83-2  
BELT LINE 2002 GROOVING

ACC BELT LINE Rd. 2002-2003

Pavement Markings

# PAVEMENT GROOVING IMPROVEMENTS

BELT LINE ROAD
 PAVEMENT GROOVING IMPROVEMENTS
"PAVEMENT MARKING PLAN"
 TOWN OF ADDISON
 AUGUST, 2002

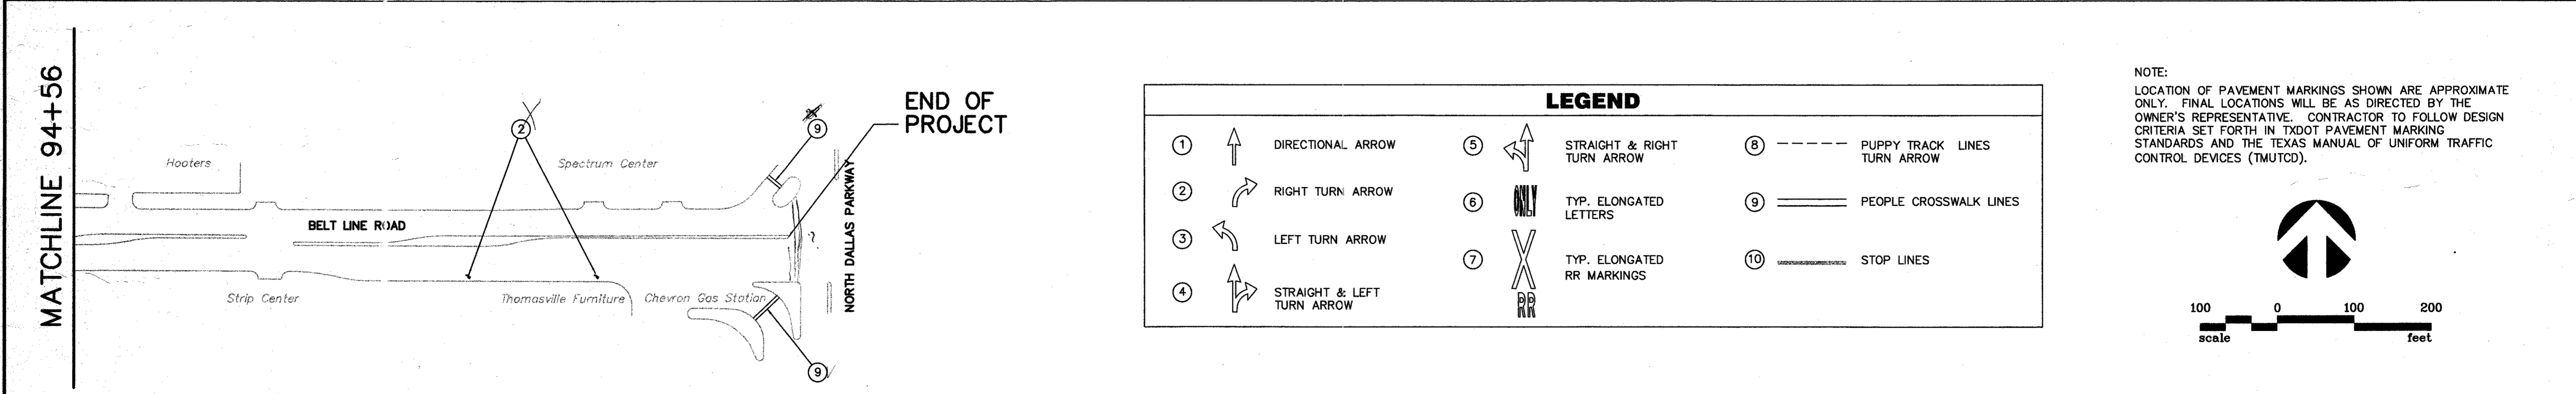
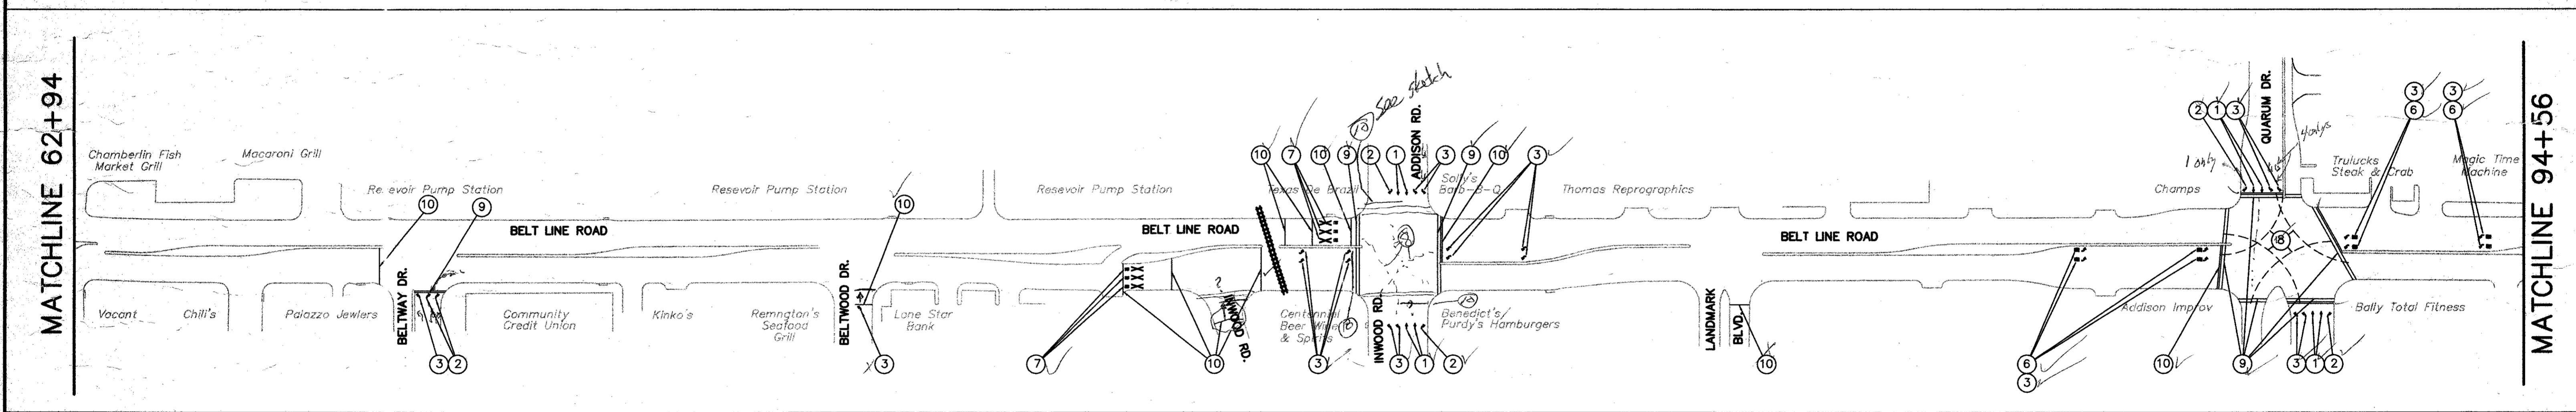
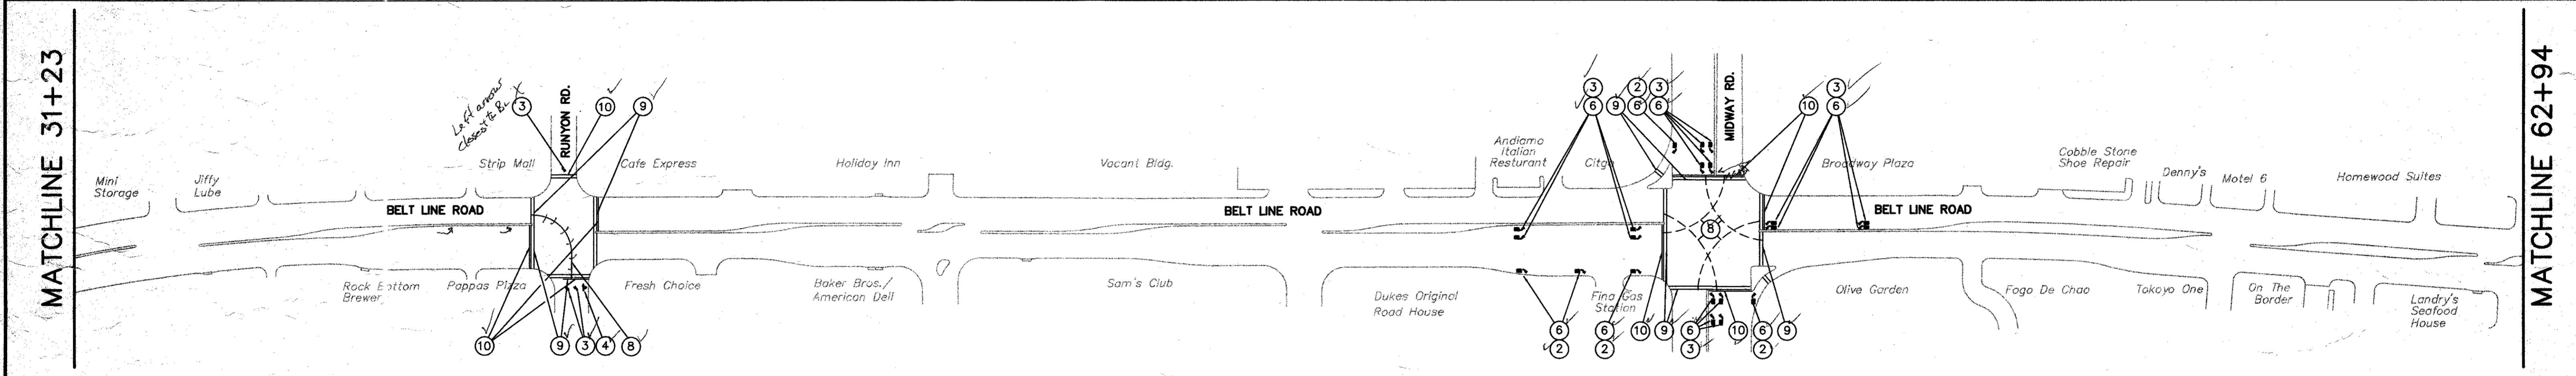
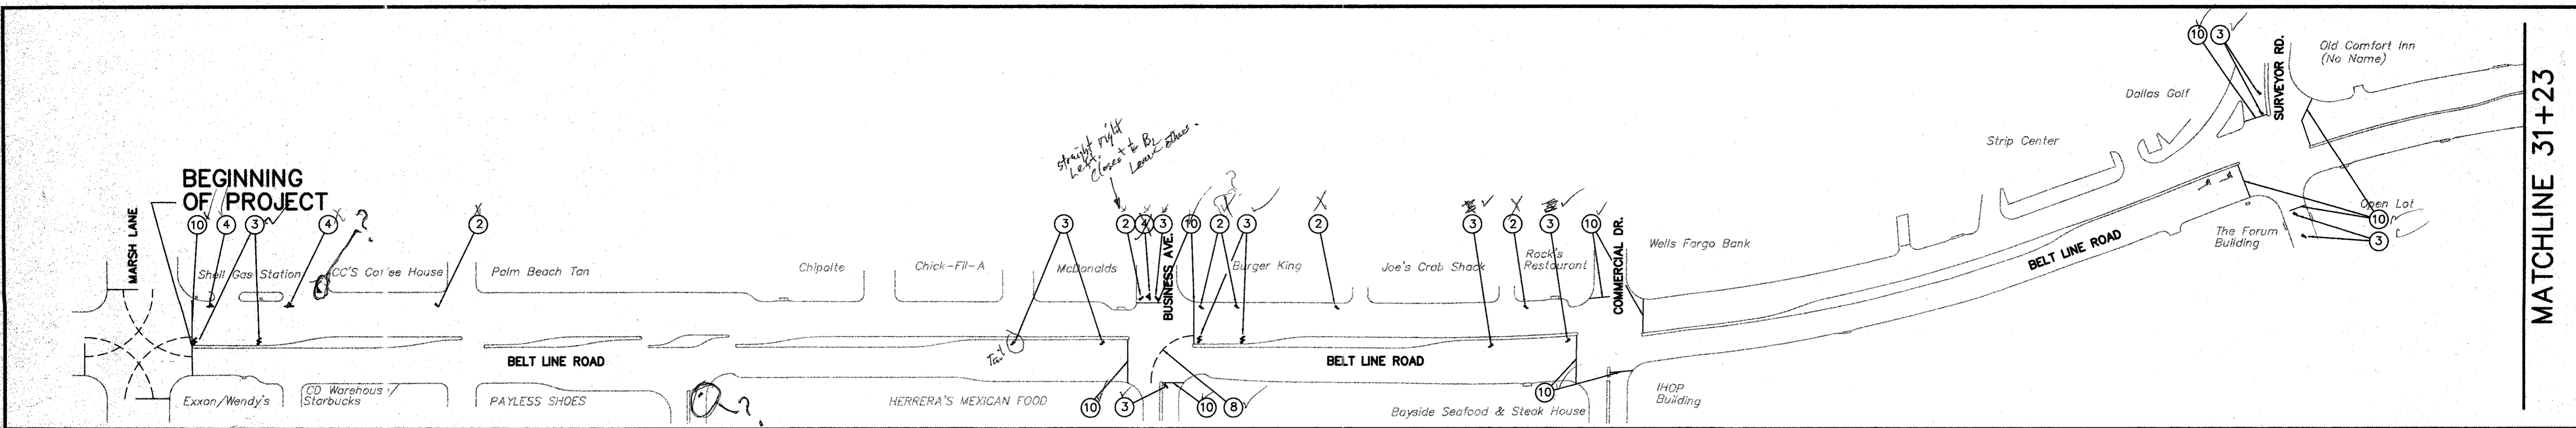
West Bound Belt Line Missing for Plan.

- 1) SB Runway - Left Turn Arrow
- 2) Local lane W of Commercial - 4 right turn Arrows
- 3) SE Business - 1 Left turn Arrow, 1 Straight/Right Arrow
- 4) Local lane @ 3711 E. - 1 Rt. arrow
- 5) WB & right lane - 2 straight/right arrows

EB Belt Line

- 1) Repair tail on arrow (first left turn arrow approaching Business)
- 2) NB Beltwood - Left arrow
- 3) NB Inwood - stop bar
- 4) NB landmark - stop bar
- 5) Local lane/Rt. turn lane approaching DP - 2 rt. turn arrows

Questions

- 1) Crosswalk @ Dallas Plwy. - Atk. diff.
- 2) Crosswalk south side of Inwood/BL between Benedicts + Candanial
- 3) Stop bars @ Inwood (NB) and Beltwood (NB) should be closer to intersection
- 4) Triangle @ Shell station is hatched, but no direction given
- 5) Bold arrow @ Bayless/Harveys NE driveway, but no direction
